From: Paul Cann
Sent: 06 March 2013 13:30
To: Planningecons; Planning.Responses
Subject: RE: Planning Consultation on: FP/25/13/

Engineers comments in respect to surface water drainage:

APPLICATION **FP/25/13/**

NO:
Registered: 18th February
2013
Site Address: Fleet Cottage The Ridgway Bognor Regis West Sussex PO22
7JQ
Grid Reference: 495536 99660
Description of Works: Demolition of existing dwelling and erection of new property
together with a new single car parking space and
carport/workshop in rear garden

Proposed Ground Floor Plan

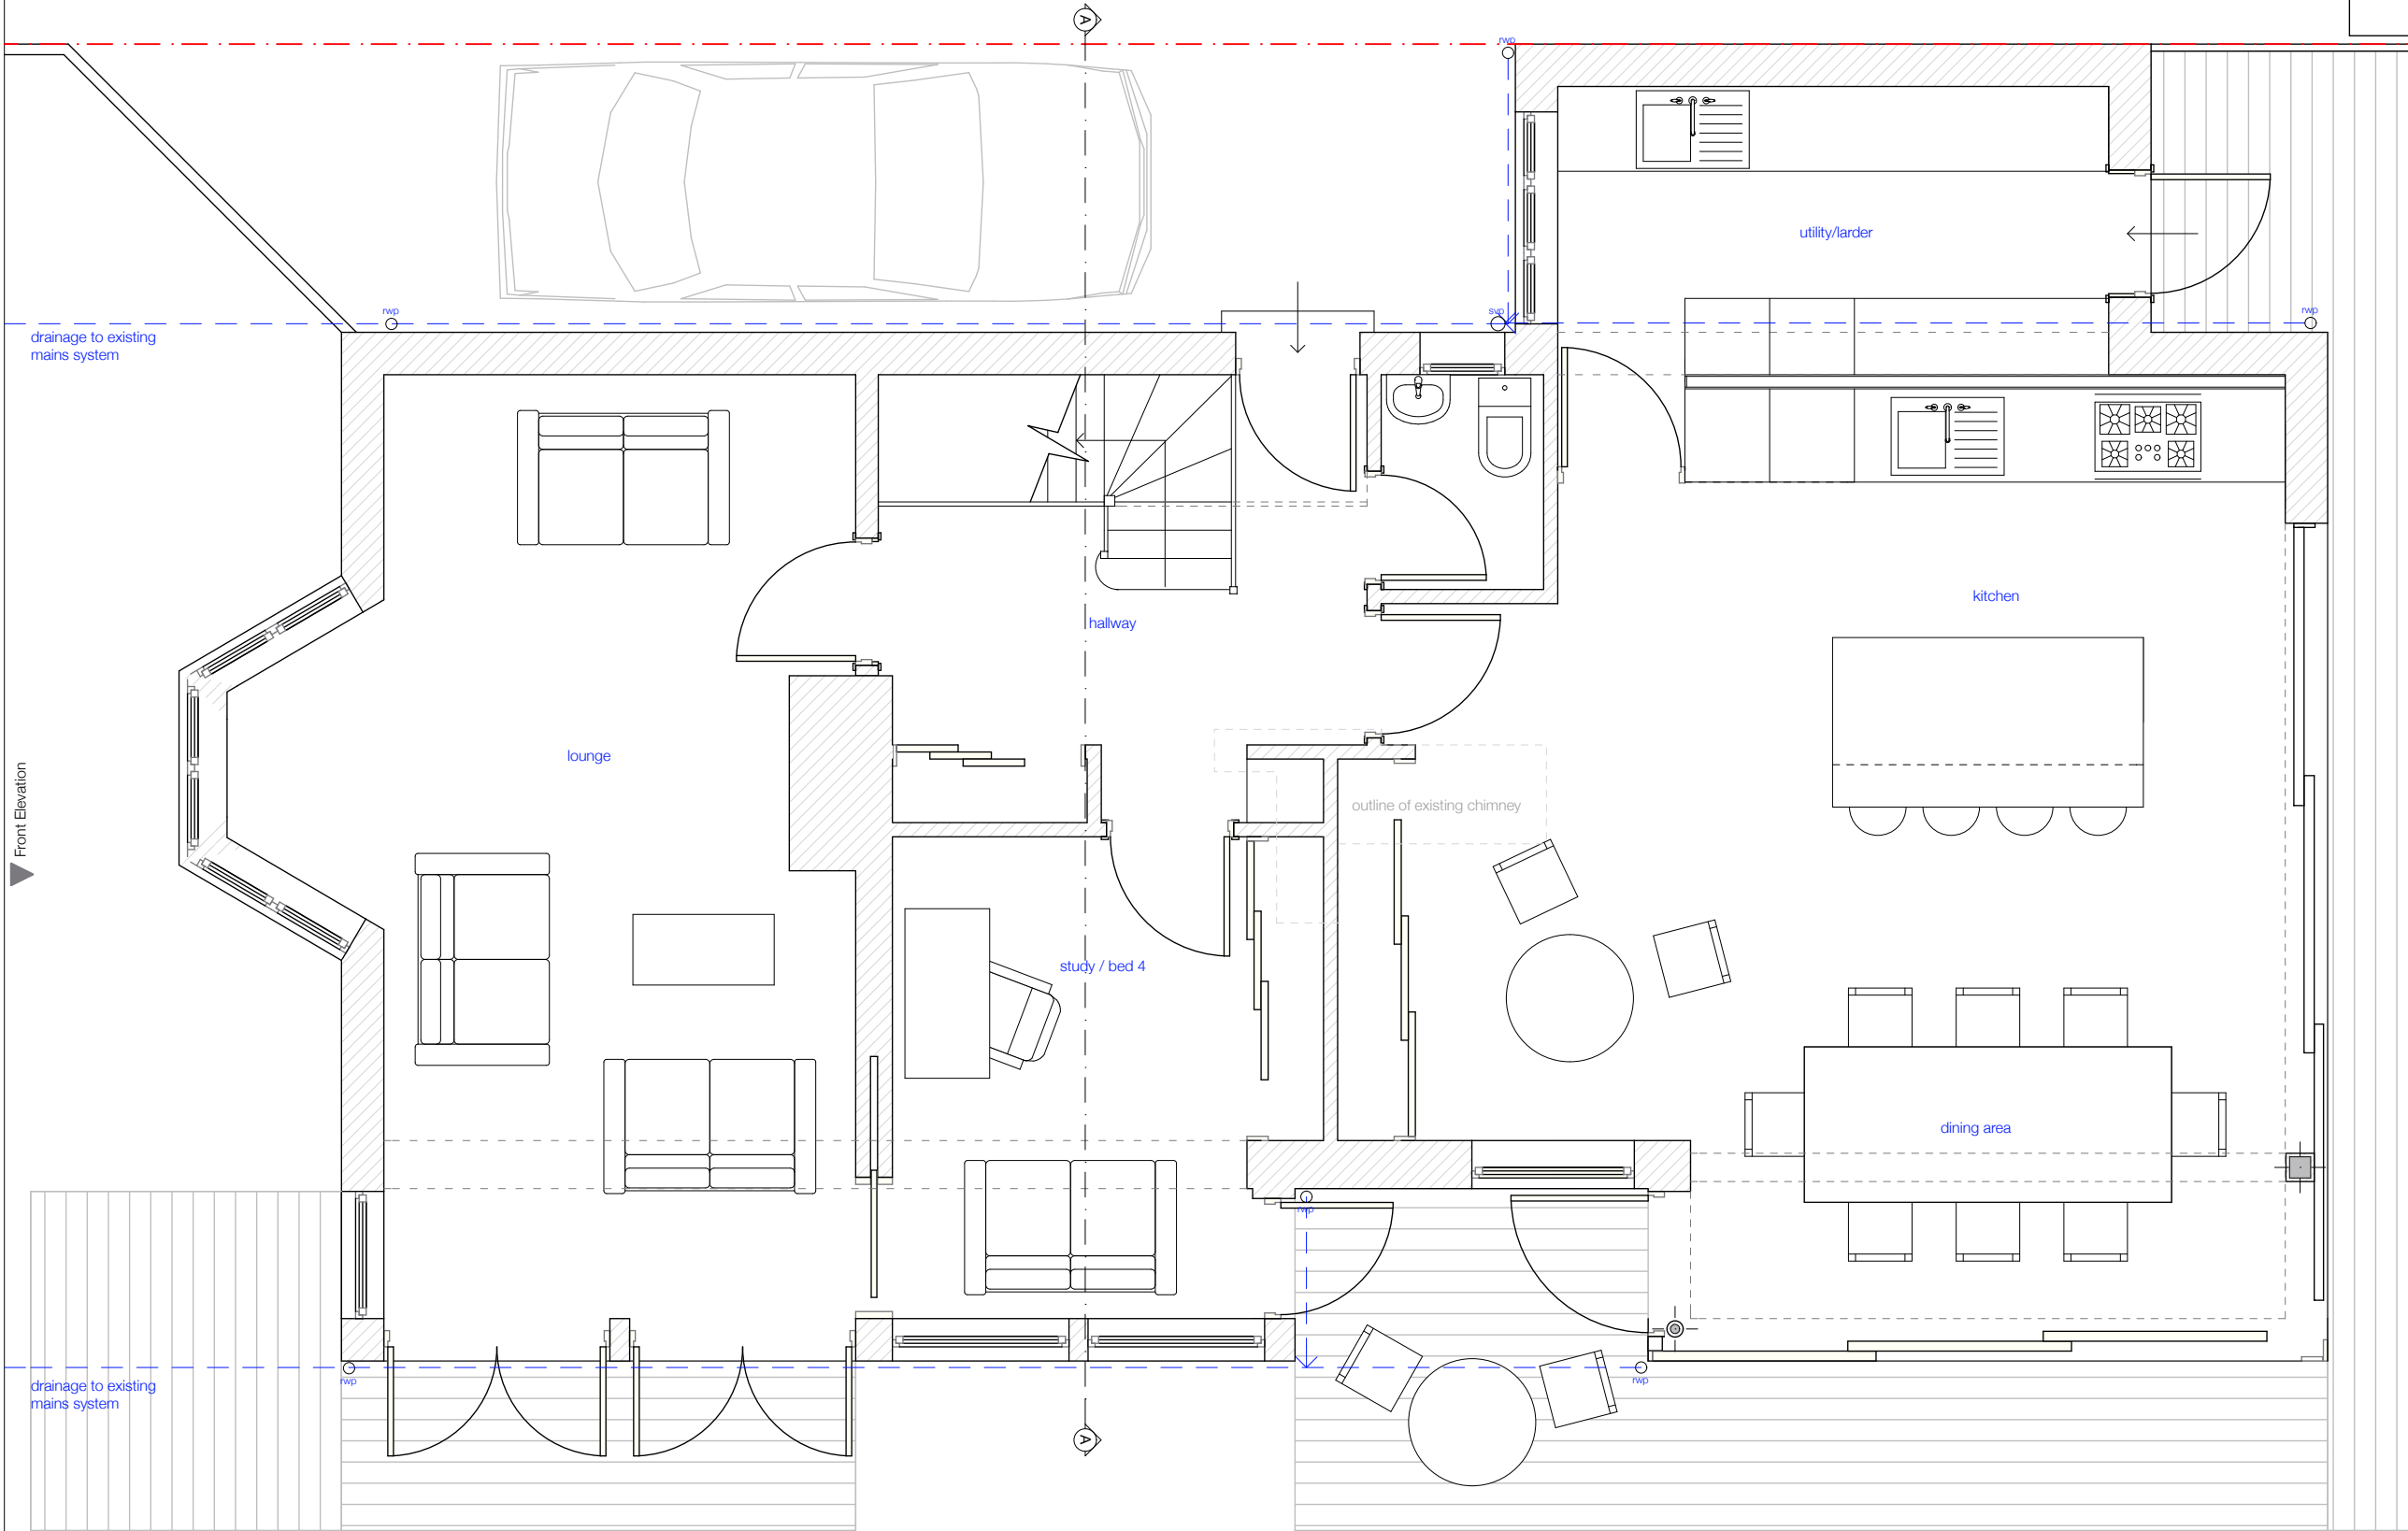
The applicant states that surface water will be disposed of to 'main sewer'. No surface water is to be discharged to the foul sewerage system. A SuDS system (Sustainable Urban Drainage System) must be investigated for surface water disposal, ie. soakage structures.

Infiltration rates for soakage structures are to be based on percolation tests undertaken in the winter period and at the location and depth of the proposed structures. The percolation tests and design must be carried out in accordance with BRE 365, CIRIA R156 or a similar approved method and cater for the 1 in 10 year storm between the invert of the entry pipe to the soakaway, and the base of the structure. It must also have provision to ensure that there is capacity in the system to contain below ground level the 1 in 100 year event plus 30% on stored volumes, as an allowance for climate change. Adequate freeboard must be provided between the base of the soakaway structure and the highest recorded annual groundwater level identified in that location.

Any SuDS or soakaway design must include adequate groundwater monitoring data to determine the highest winter groundwater table in support of the design. The extent of the winter groundwater monitoring will need to be agreed with ADC Engineers.

Please apply standard condition ENGD2A.
